Norfolk Vanguard Offshore Wind Farm

Statement of Common Ground

Norfolk County Council

Document Reference: Rep3 - SOCG - 15.1

TITLE  
B1149 TRAFFIC MANAGEMENT

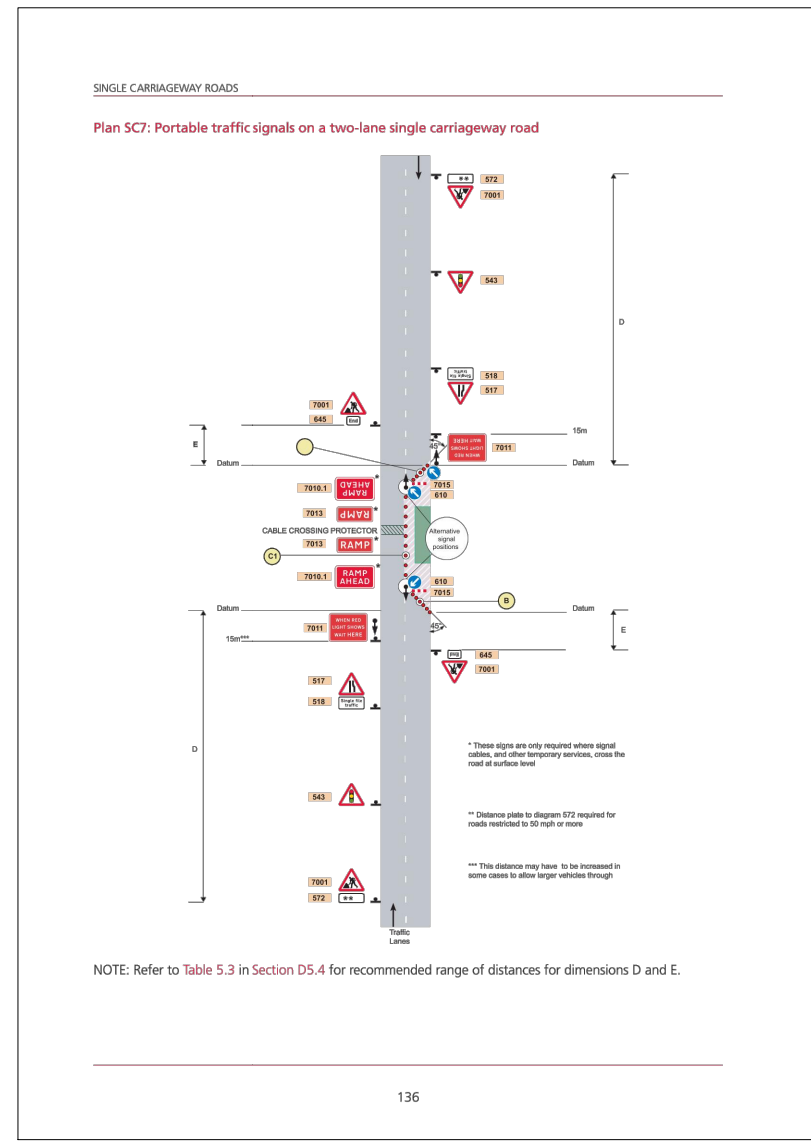
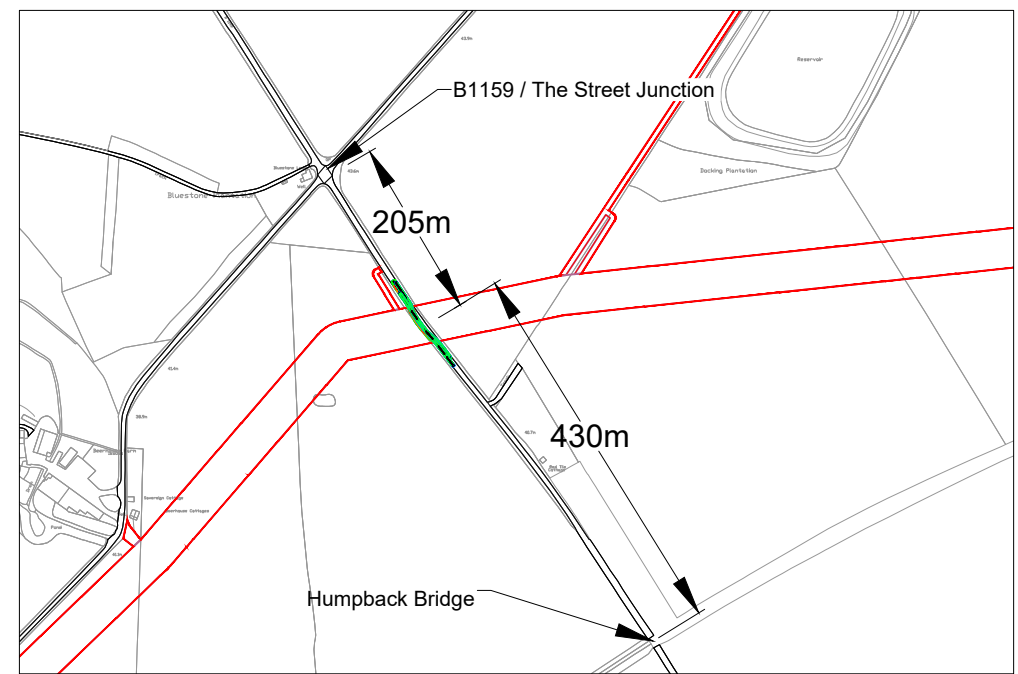
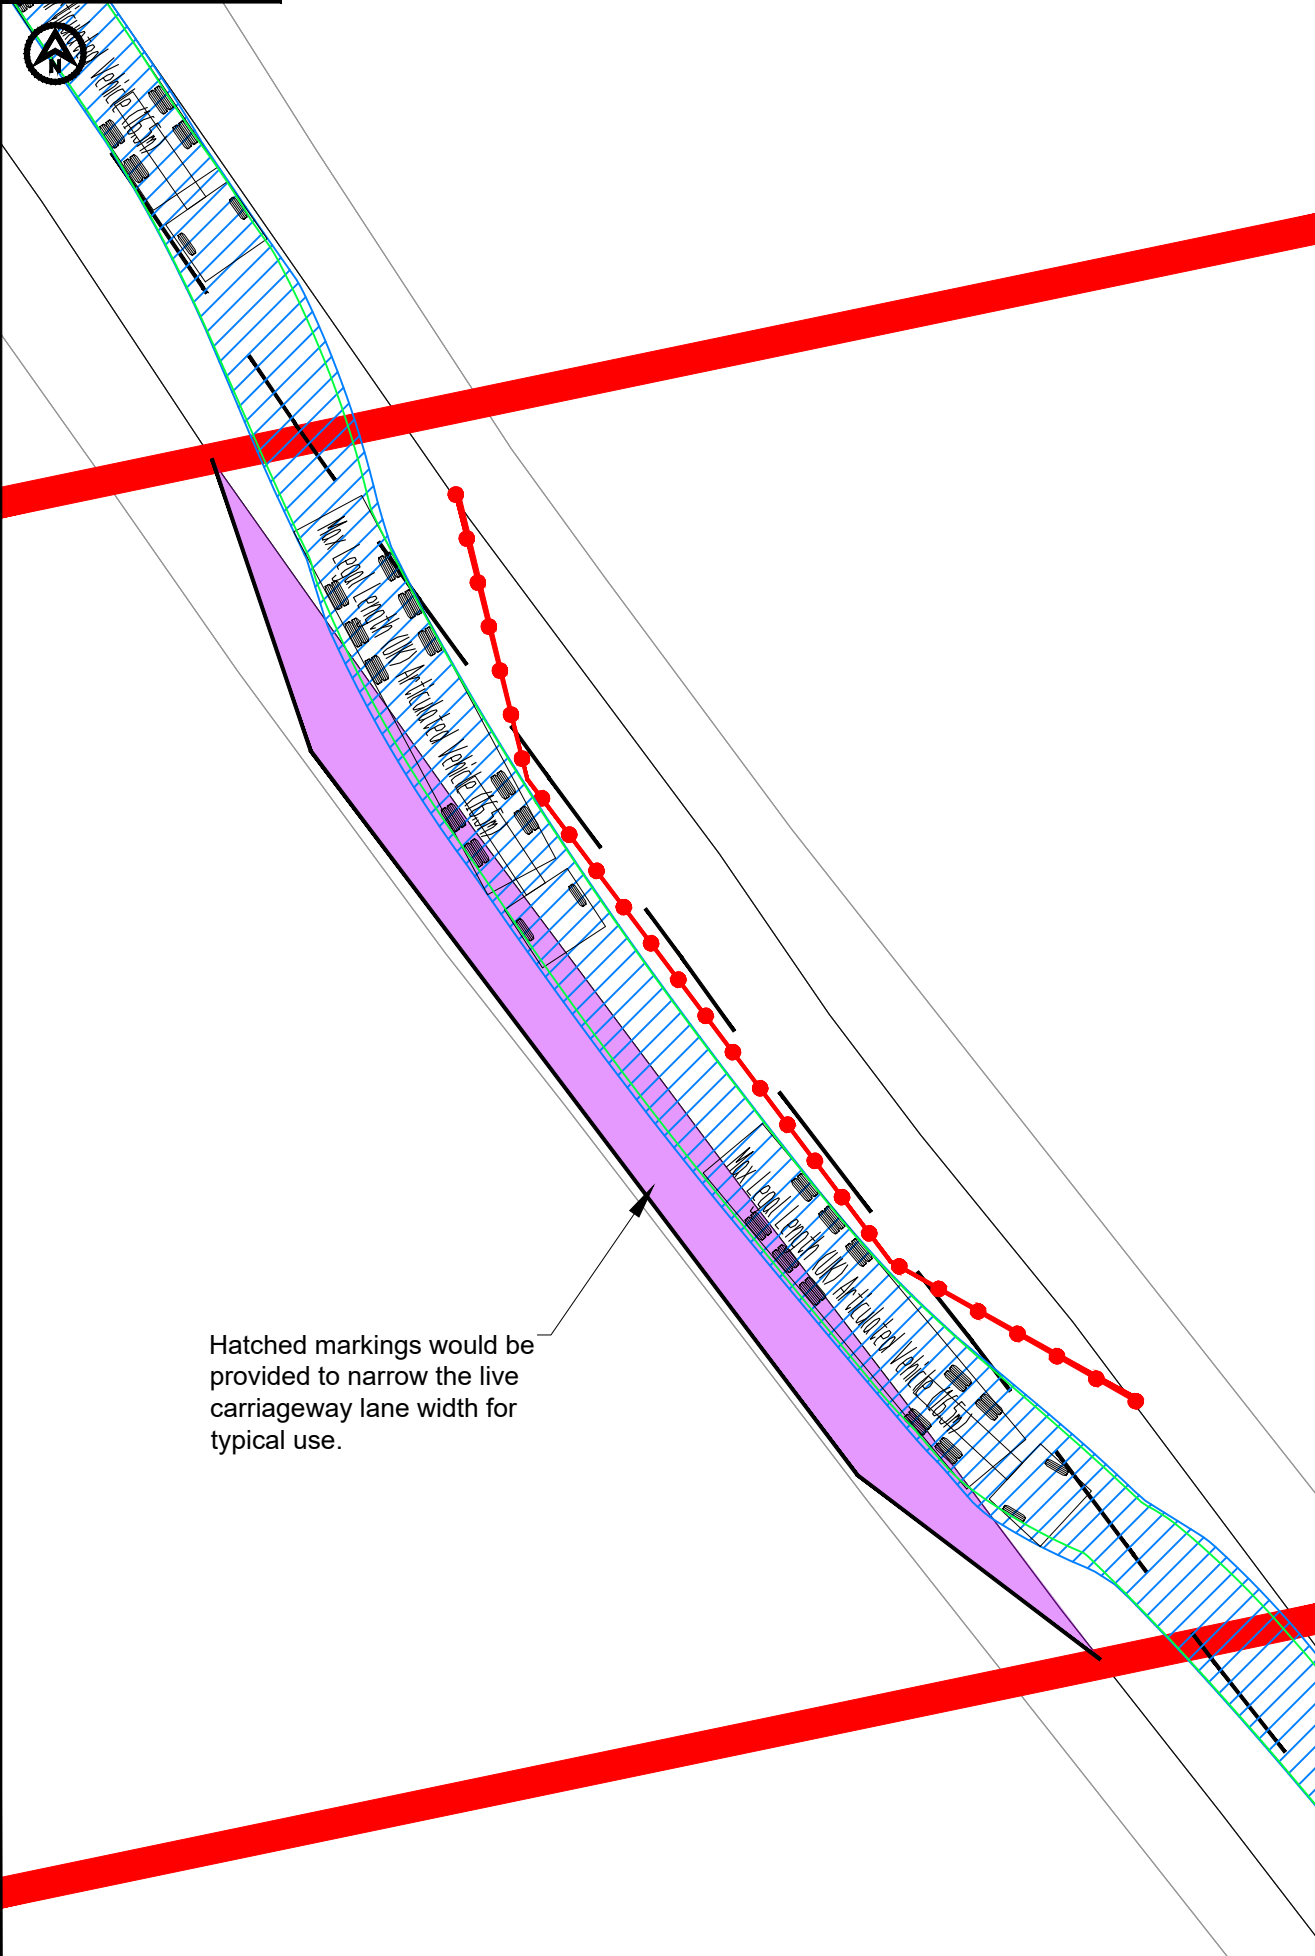
B1149 crossing An investigation has been undertaken in response to the concerns raised by NCC on the potential impacts of open cut trenching on the B1149 and was submitted to the examination at Deadline 7.5 (ExA;AS;10.D7.51). The findings are summarised below: • Forecast cumulative traffic flows were examined and would fall well below the total vehicles per hour level at which single lane traffic management would lead to network disruption. • A drawing has been provided showing the swept path of vehicles (including abnormal loads) which demonstrates that the proposed traffic management is viable. • Norfolk Partnership Laboratory (NPL), investigated ground conditions at the B1149 to ascertain if an appropriate road reinstatement specification (to address additional concerns raised by NCC) would be feasible. The testing indicates that the road subsurface has good load bearing properties and a specification was identified for the reinstatement that liability.	The applicant's method of working is not safe. The swept path analysis does indicate that large, articulated vehicles will be able to negotiate the works area, albeit with very little clearance. However, the swept path analysis is totally reliant upon a 0.5m safety zone outside the work area. (ie the buffer between vehicles and roadworks/the open trench excavation). This is a National Speed Limit road, so should have a 1.2 m safety zone. Whilst this can be reduced with the use of a Temporary 30mph Speed Restriction, it is not so in the case of the excavation exceeding 1.2 metre depth.	This is not acceptable to NCC on health and safety grounds.

Topic	Norfolk Vanguard Limited position	Norfolk County Council position	Final position
	An open cut trench crossing is therefore deemed appropriate as there is no evidence from the investigations to suggest that this form of open cut crossing and associated reinstatement will cause significant adverse impacts or present a maintenance liability for the Norfolk County Council.	The increased safety zone is related to the potential for trench shoring and consideration for ground conditions and angle of repose in the soil. NCC do not believe this can be mitigated. In the circumstances irrespective of whether PINS grant consent or not, the applicants cannot proceed with open cut trenching unless they can provide a 1.2m wide safety zone – which at present they cannot do. In the circumstances NCC must insist that trenchless crossing is used, and NCC accept no liability should an unsafe method of working be approved by PINS – including any subsequent action for manslaughter.
